Development Control  
Ribble Valley Borough Council

**Re:** Planning Application 18/0296

**Address: LAND REAR OF ROCKLEA AND STANDRIDGE WHALLEY ROAD  
BB7 9NA**

**Description: ERECTION OF THREE DETACHED, THREE-BEDROOM  
BUNGALOWS INCLUDING ACCESS.**

PROPOSED SITE PLAN

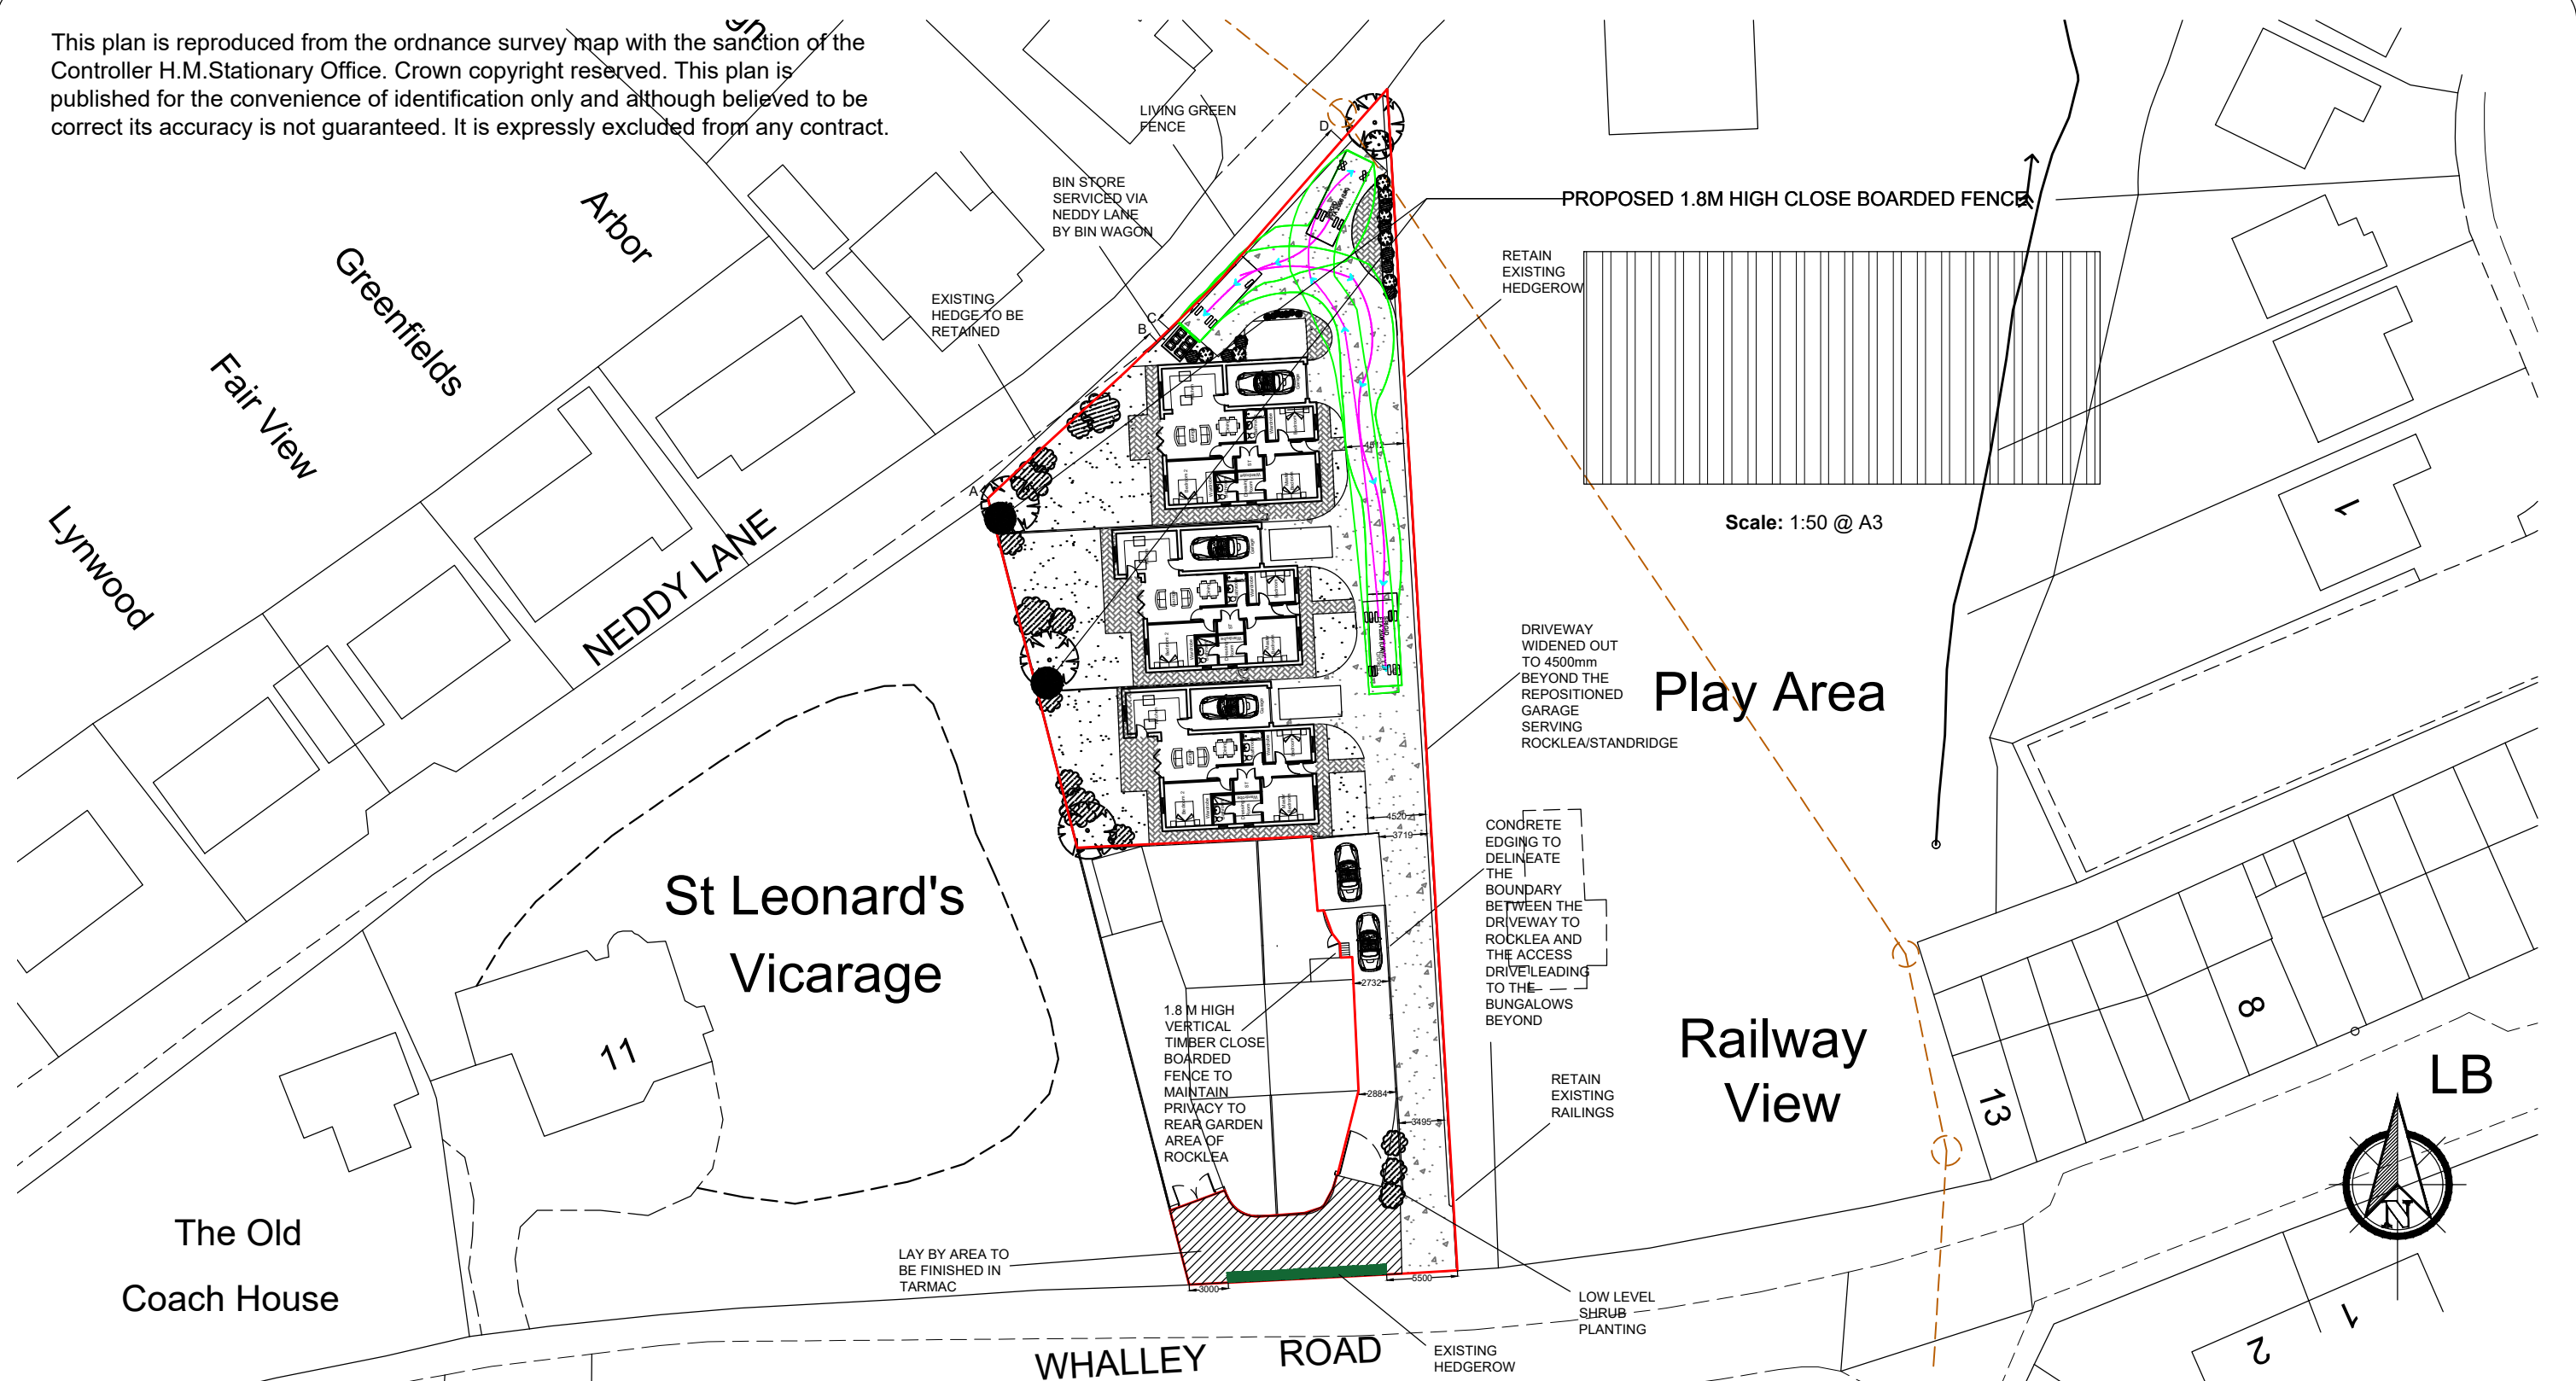
- Regarding the fence that is to be removed from the boundary of Rocklea whilst this will be an improvement in the short term, we do not see how this can be conditioned not to be replaced in the future should Rocklea be sold.
- There is a concern that the bushes shown outside Rocklea will obscure the sightlines along the new drive
- There may be insufficient room for the new turning head there is known to be a large hedge which will require removal to facilitate the turning head. The turning head swept path also shows movement across the drive of plot 3 which may be blocked by a vehicle.
- The waste collection point is too remote from Plot 1. The Department for Transport's Manual for Streets document would suggest that residents would not be expected to carry waste more than 30m to the collection point and that

the collection vehicle should be able to get within 25m of the point. There appears to be no location shown for bin storage on each individual plot.

- The parking space for plot 3 is narrower than would be expected, it is narrowed by obstructions on both sides, it should be wide enough to allow for the car doors to be opened without fouling against an obstruction such as a fence or hedge it would be expected that an additional 0.6m in width should be provided.
